**WEST SUSSEX COUNTY COUNCIL
STRATEGIC PLANNING CONSULTATION**

**SUBJECT: A/140/13 - Two storey rear extension to existing building with dormer to side of existing roof and new vehicular access and crossover to existing stables.
ADDITIONAL INFORMATION RECEIVED**

Brackenside, Dappers Lane, Angmering, West Sussex, BN16 4EN

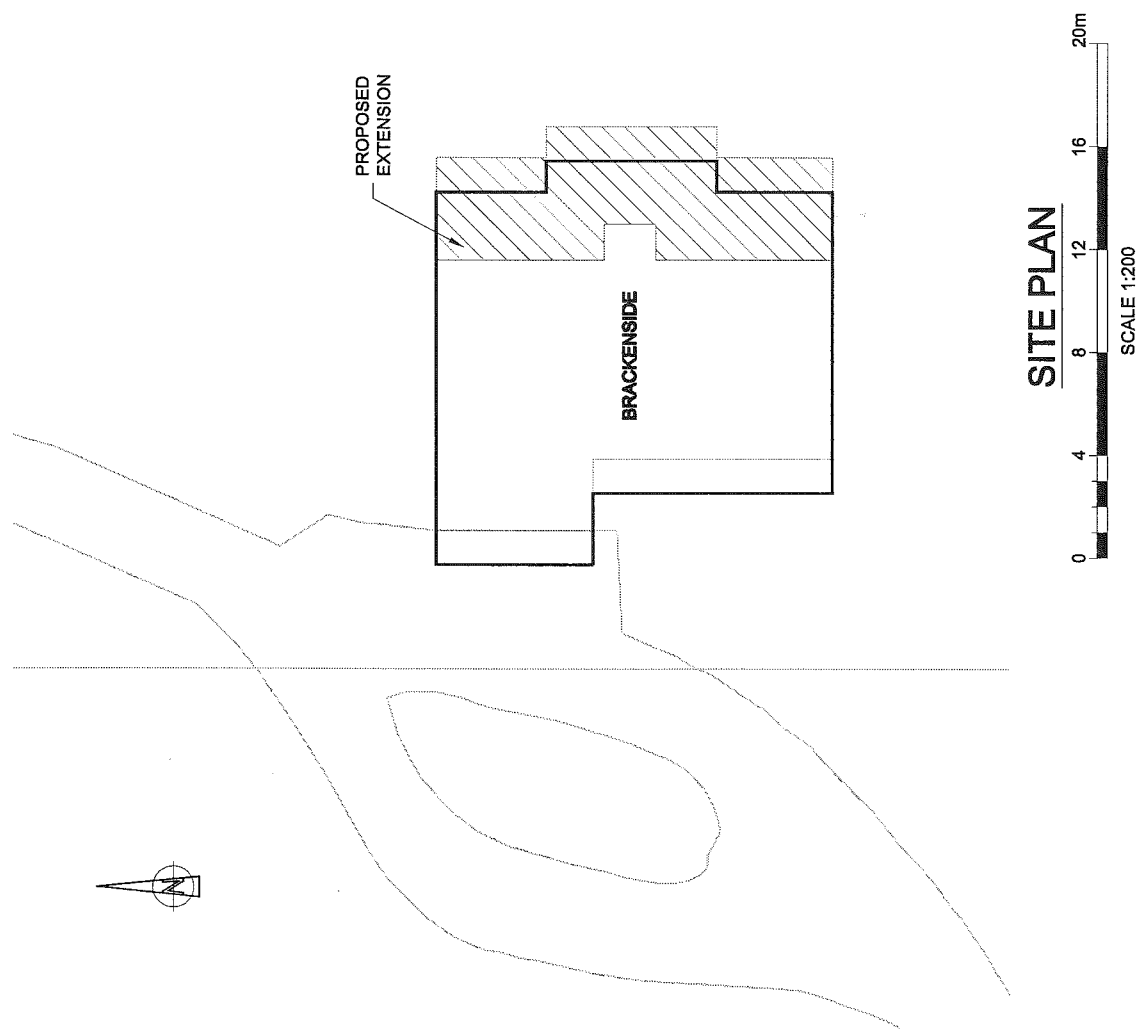
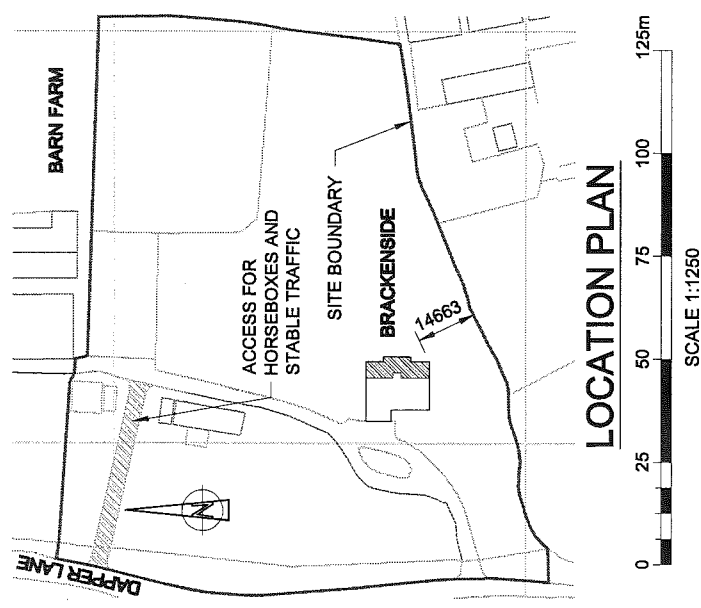
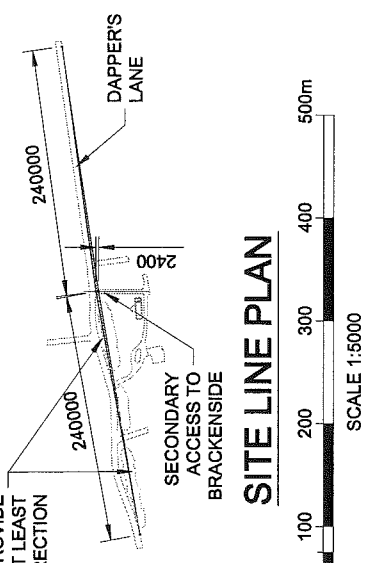
A revised site plan has since been submitted with visibility splays of 240m in each direction. From inspection of the plans and information available, it would appear the applicant has suggested that by butting back existing hedgerow the visibility splays can be achieved. The application boundary suggests that the applicant doesn't own the entire land that the hedgerow is situated. However, after reviewing the newly submitted plan that gives more of an idea of what visibility can actually be achieved, I am content that visibility site lines of maximum achievable is adequate to be conditioned to this planning consent. Therefore, the hedgerow that can be cut and maintained by the applicant should be done so in order to provide these maximum achievable splays.

Overall, no concerns are raised to this application from a highways perspective subject to a condition securing maximum achievable visibility splays in each direction.
